18 April 2023

**SSD 9978934: Submission regarding critical remaining safety issues as a result of the redevelopment of Cockle Bay Park**

**Reference: Cockle Bay Park Redevelopment SSDA - Transport Review**

COCKLE BAY PARK  
 Loading Dock Swept Path Assessment - Level Ground  
 Wheat Road / Harbour Street

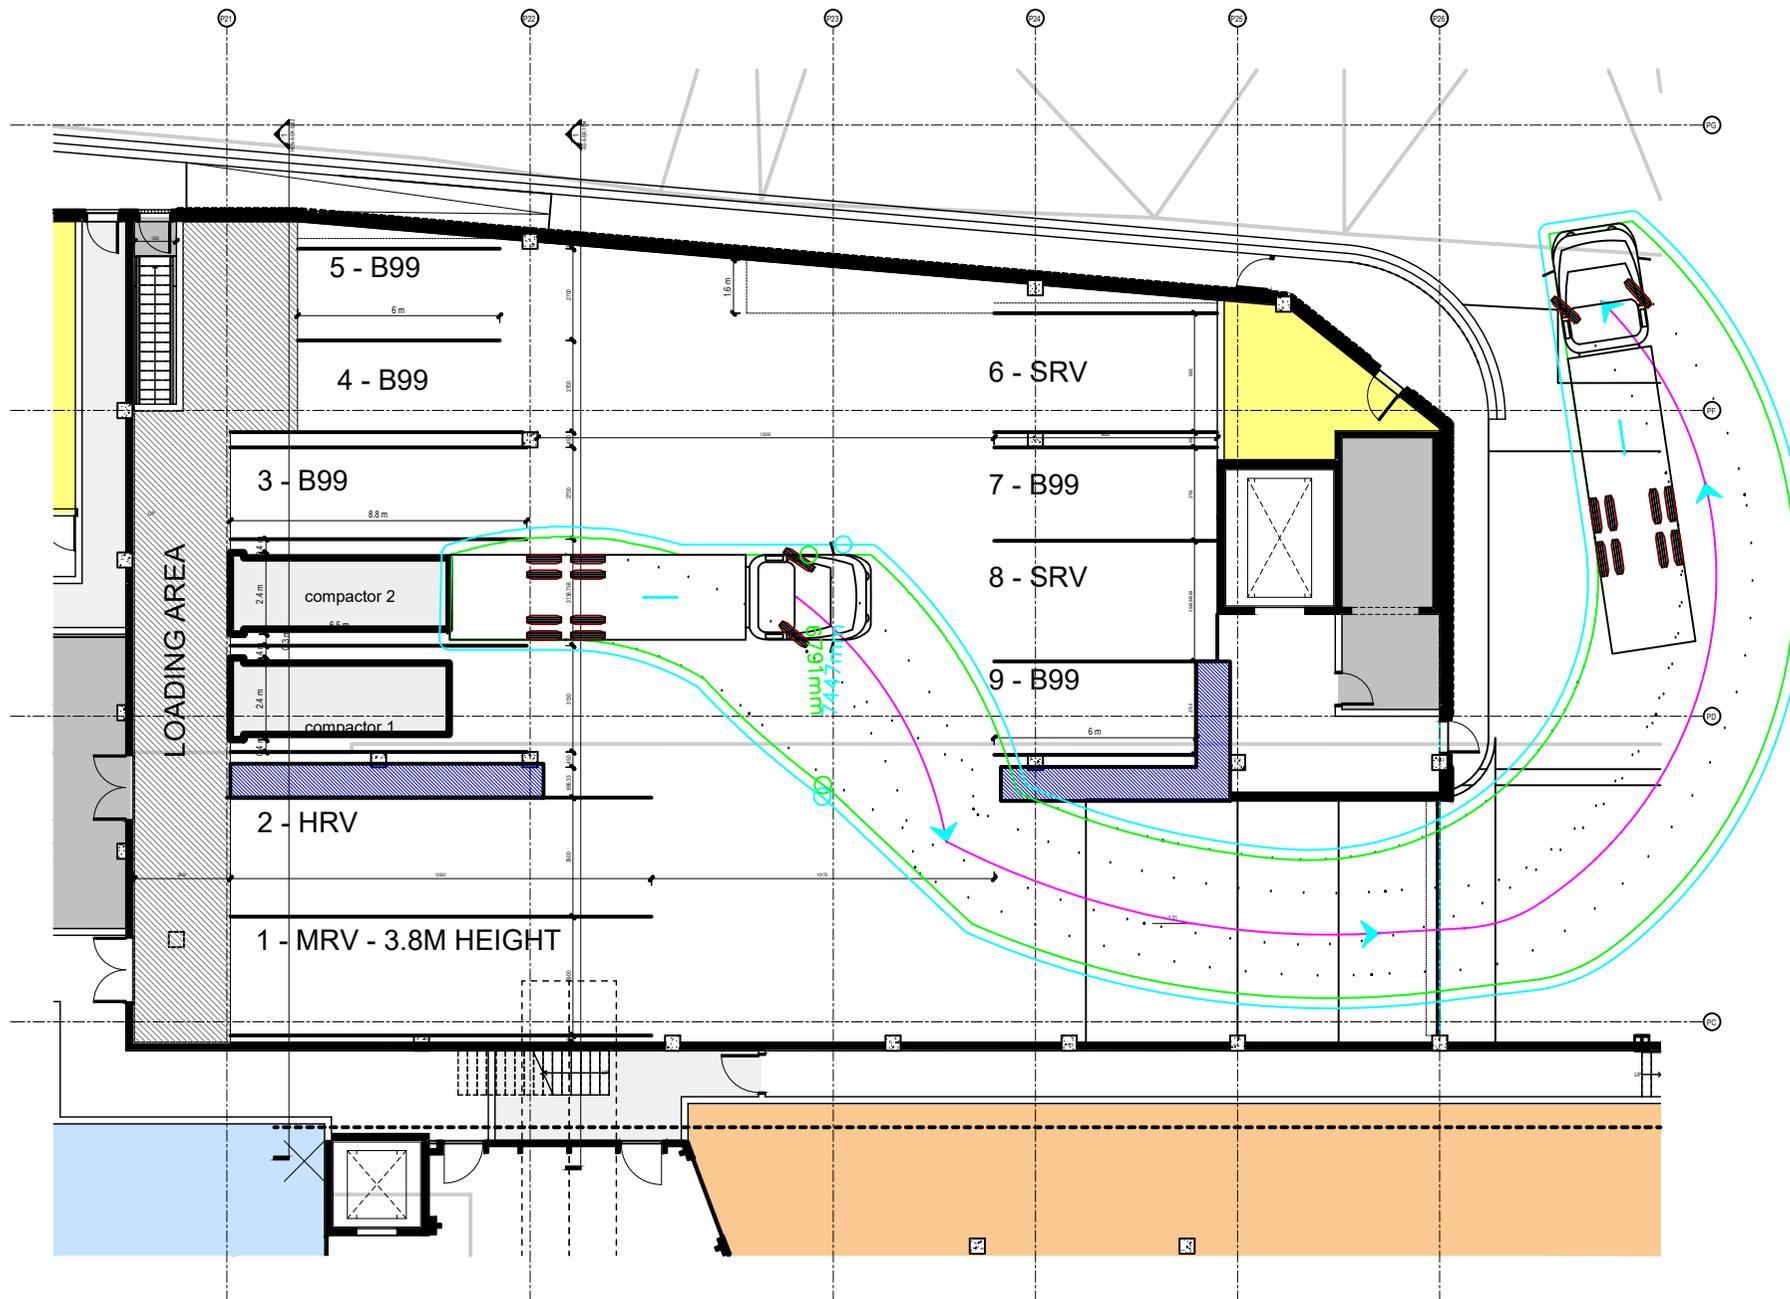
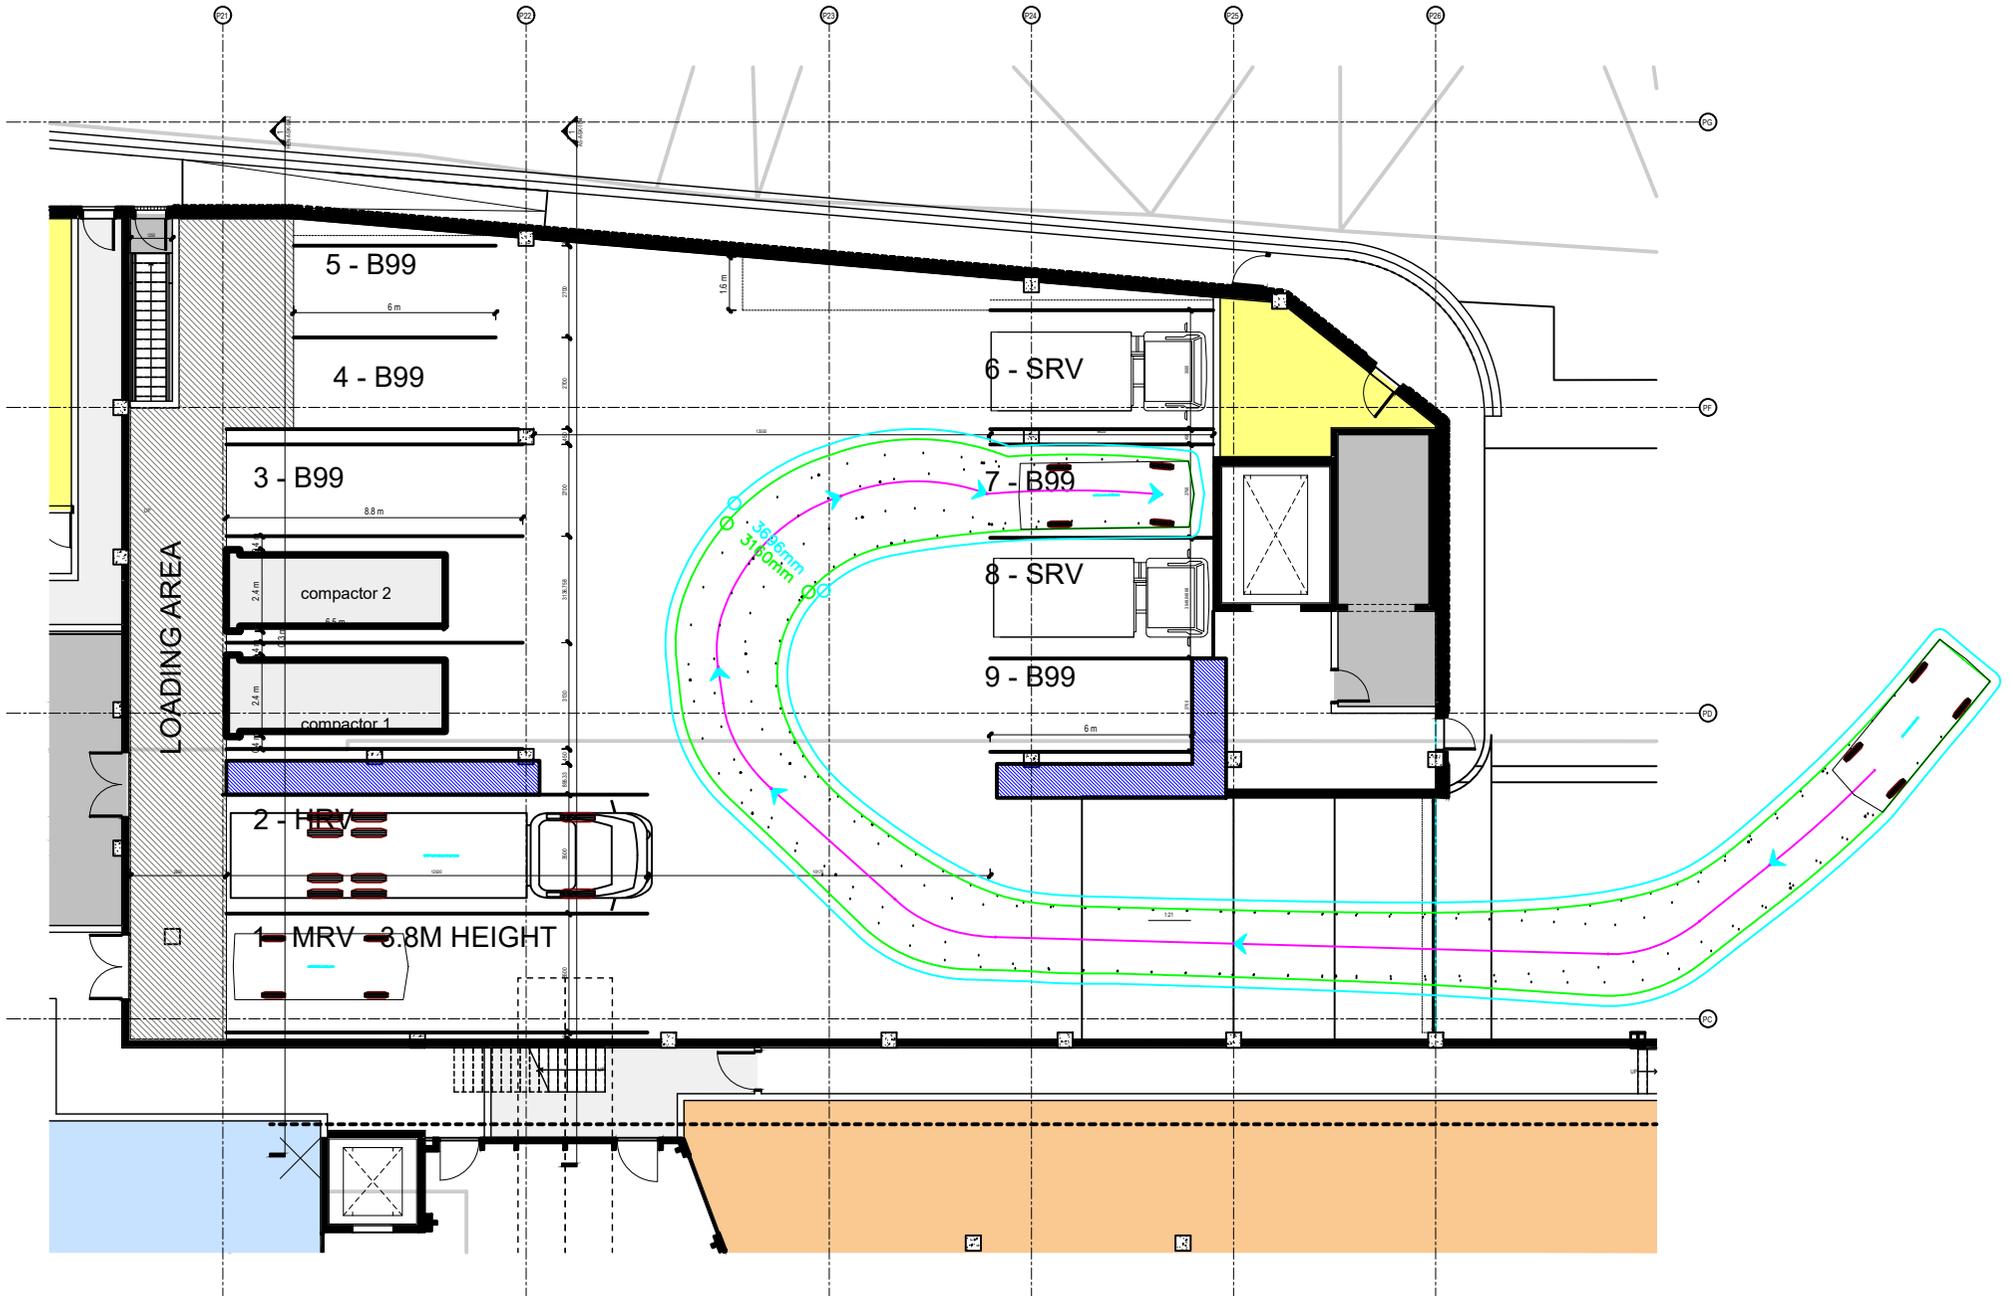
- 4.2 The proposed design of the loading bay does not allow for all types of vehicles to simultaneously pass while entering and exiting the loading bay. The impact of this design may lead to incidents within the loading bay and congestion for users of the associated roads.

- 4.3 The proposed design of the loading dock only allows for the safe simultaneous passing of two B99 vehicles (vans and utilities) or one B99 and a Small Rigid Vehicle (SRV). Two SRVs are only able to pass each other with a minimal clearance of 300mm. The simultaneous passing of a SRV and a Medium Rigid Vehicle (MRV) cannot be achieved in the proposed loading dock design. This would require vehicles to adjust speed and give way to each other. The only way that passing would be possible is for the opening to be increased by 1.5m. The Stantec Advice identifies that despite dock management protocols, any delays for vehicles navigating each other to/from the CBP loading dock will delay vehicles departing The Ribbon and/or present safety issues given the complexity of the immediate area.

- Further compounding this situation is the inability for an 8.8 metre Medium Rigid Vehicle to independently pass another similar or smaller truck along the CBP loading dock access driveway (as illustrated in Figure 5); scenarios that are probable given there are two Medium Rigid Vehicle and two Small Rigid Vehicle bays proposed in the CBP loading dock, with the dock expected to receive 400 deliveries daily or 30 deliveries per hour (a delivery every two minutes) based on a 14 hour loading dock operating hours<sup>1</sup>. Although dock management protocols (e.g. staggered booking times) are proposed manage the situation, any delays for vehicles navigating past each other to/ from the CBP loading dock will delay vehicles departing The Ribbon and/ or present safety issues given the complexity of the immediate area, therefore having further consequences to the operation of The Ribbon (as well as the CBP loading dock) and potential knock-on effects on Harbour Street traffic flow.

- Swept path analysis completed as part of this transport review suggests that the CBP loading dock access driveway would need to be widened by at least 1.5 metres to accommodate independent two-way traffic flows for all design vehicles, as illustrated and highlighted in the Figure 6 alternative design.

- 4.7 If the proposed loading dock is increased in width by 1.5m, this will allow all vehicle types to simultaneously pass each other with the addition of clearances. Cockle Bay Park and the W Hotel will then both have a viable traffic solution that is sufficient for both services and with a reduced risk of injury.
